Our Ref: P/43/20/HH

**Town & Country Planning Act 1990 (as amended)
Town & Country Planning (Development Management Procedure) (England) Order 2015
Application for Planning Permission for Works or Extension to a Dwelling**

Development Single storey rear and side extension

Location 7 Barons Mead Pagham

GROUND FLOOR PLAN 1:50

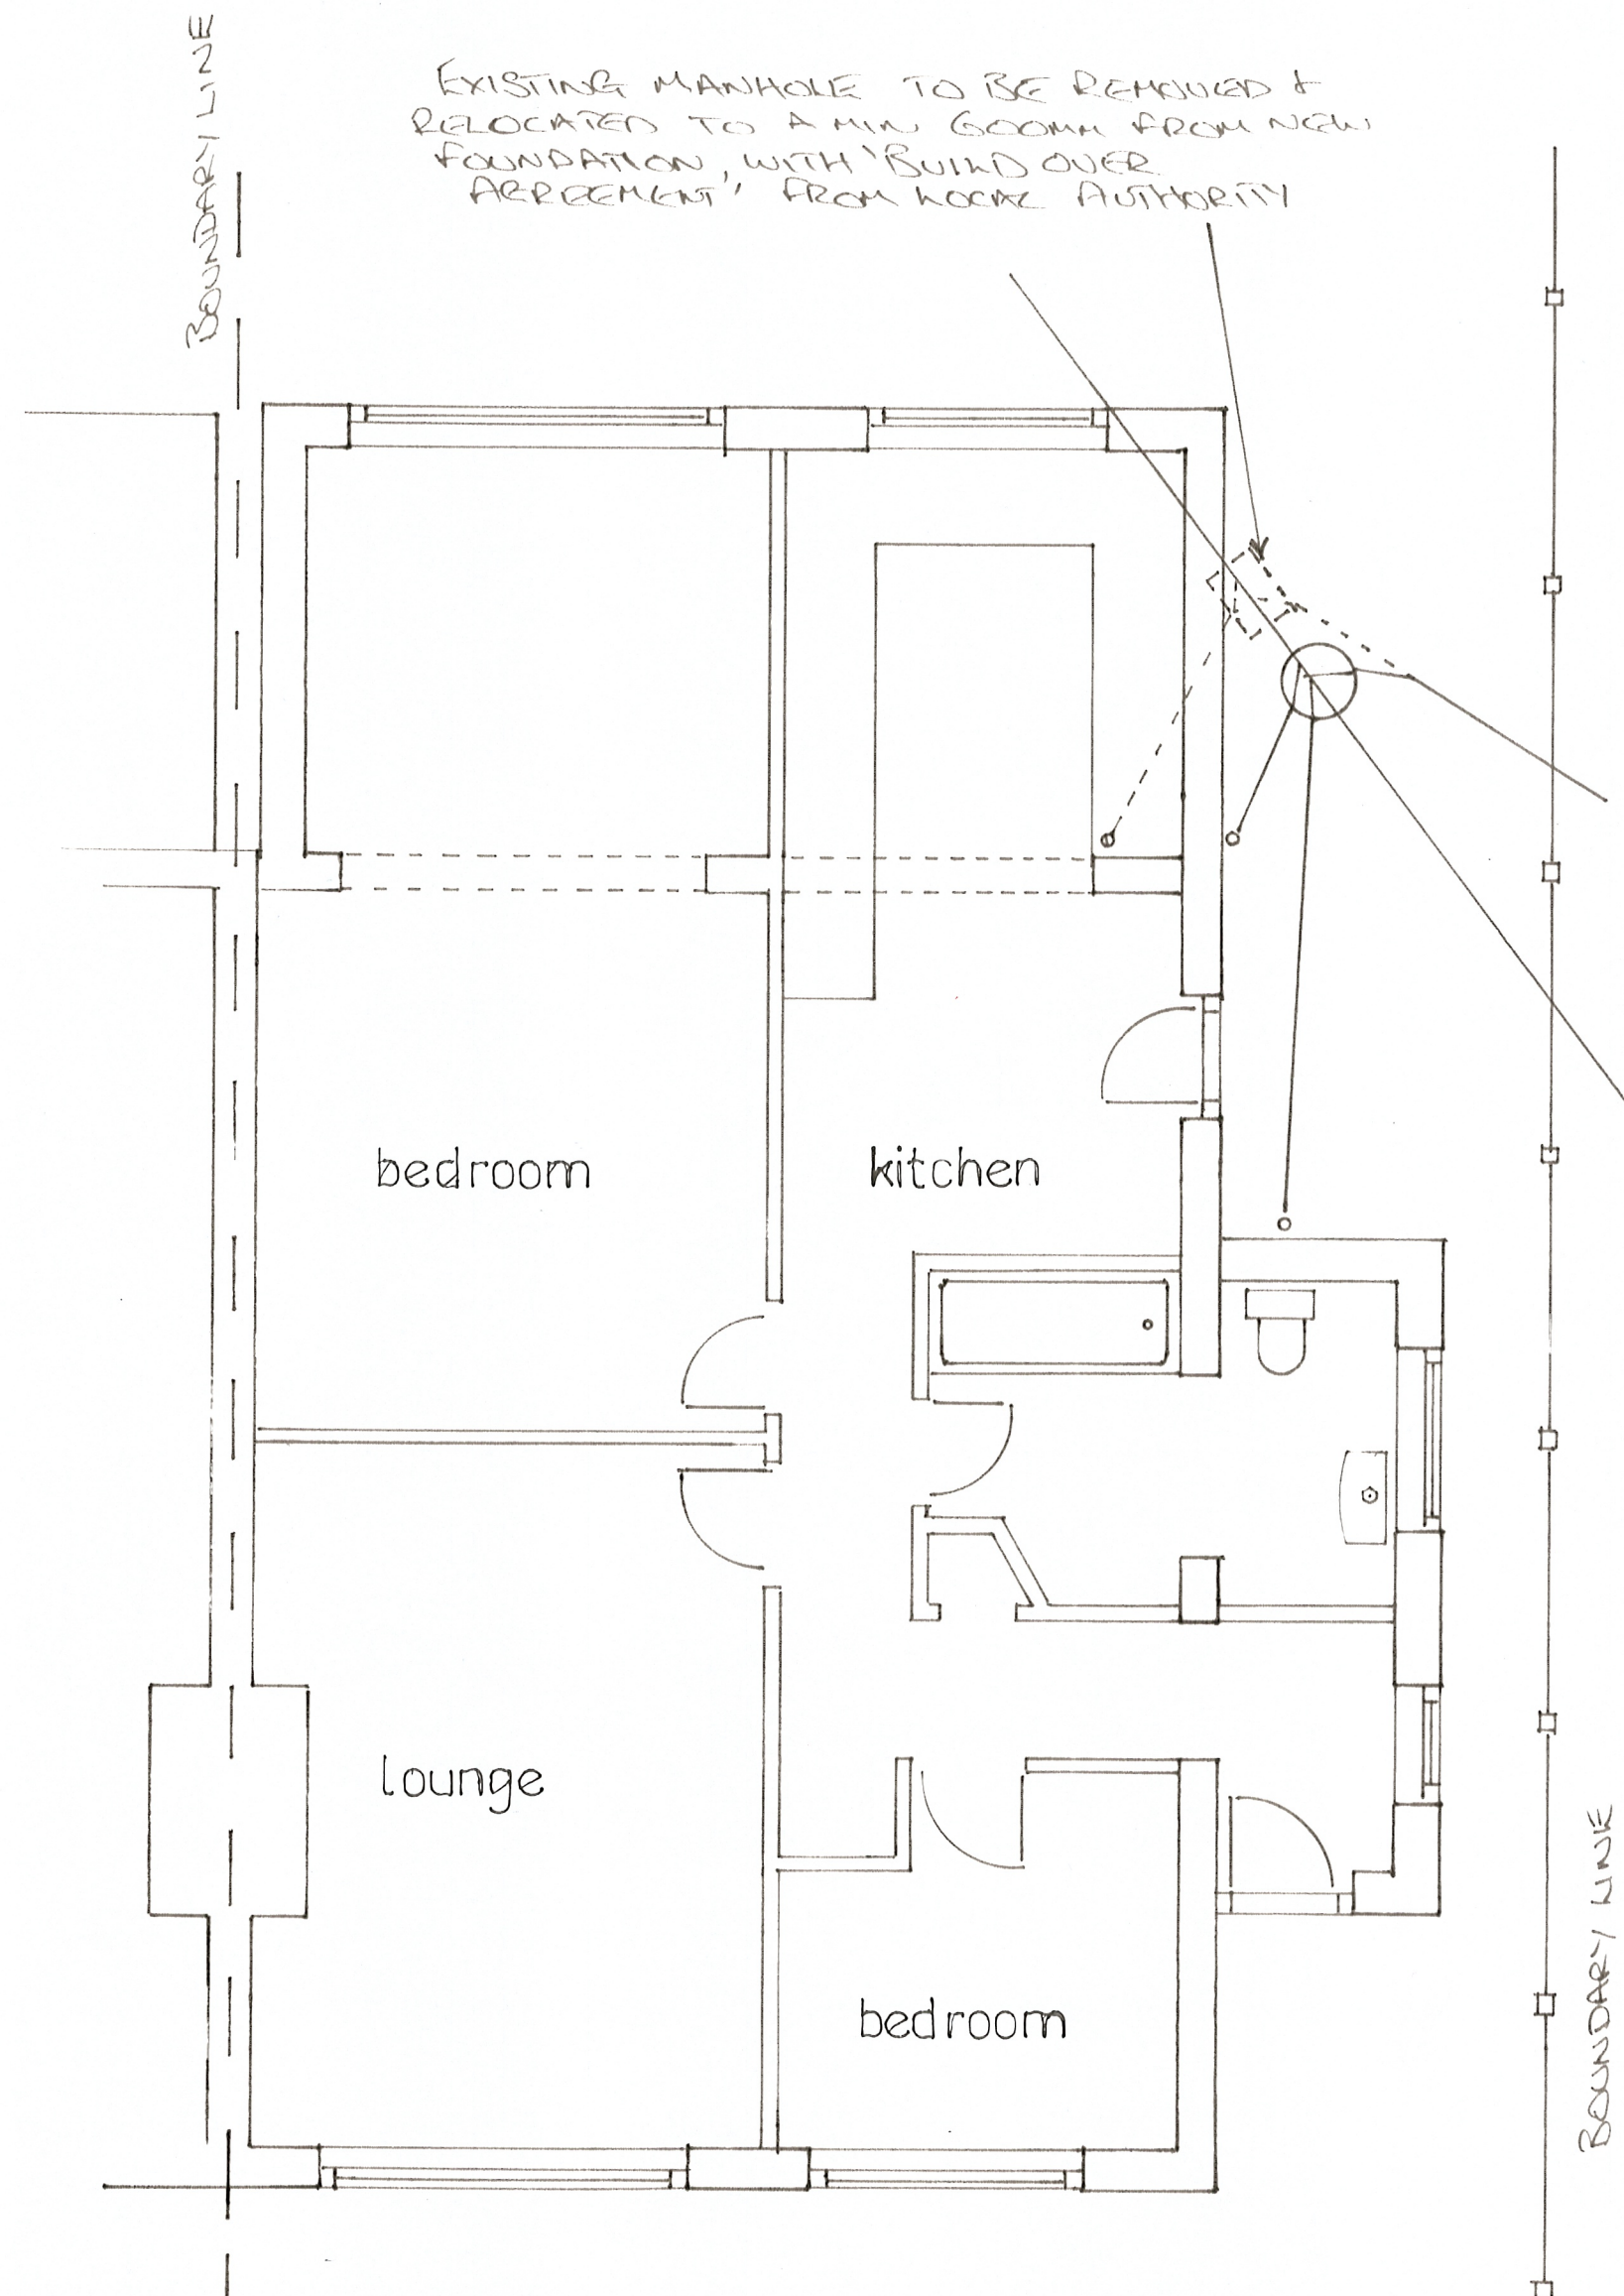
Room Labels: You are required to include room labels on all floor plans.

block plan 1:500

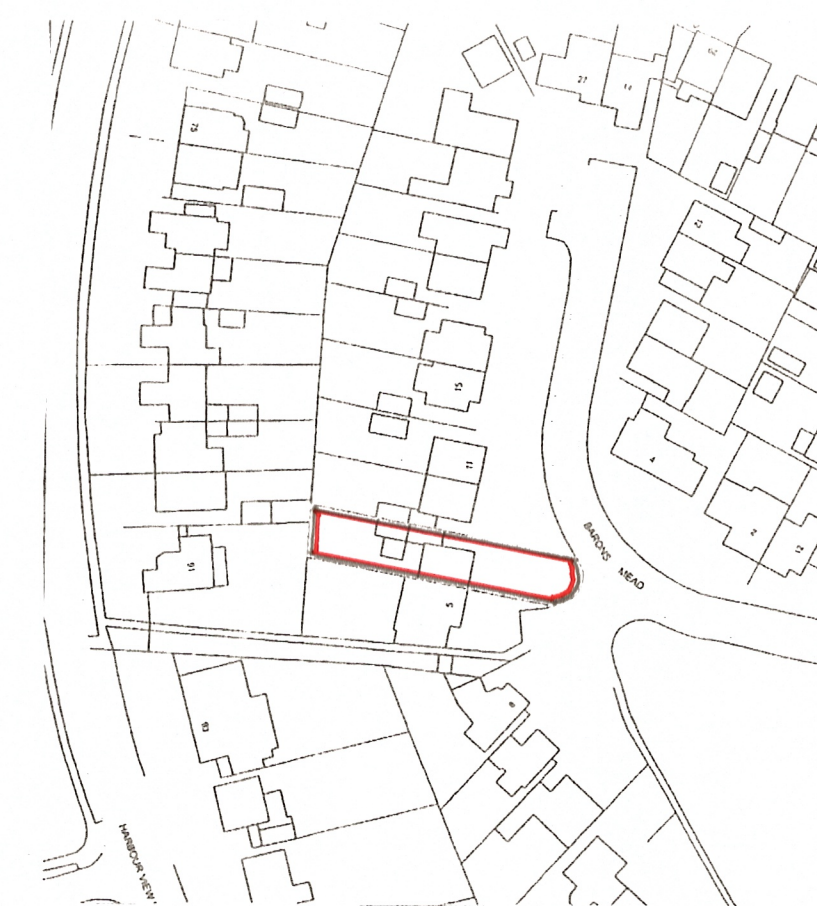
Proposed Block Plan: You are required submit a proposed block plan and include dimensions from the proposed extension to all site boundaries.
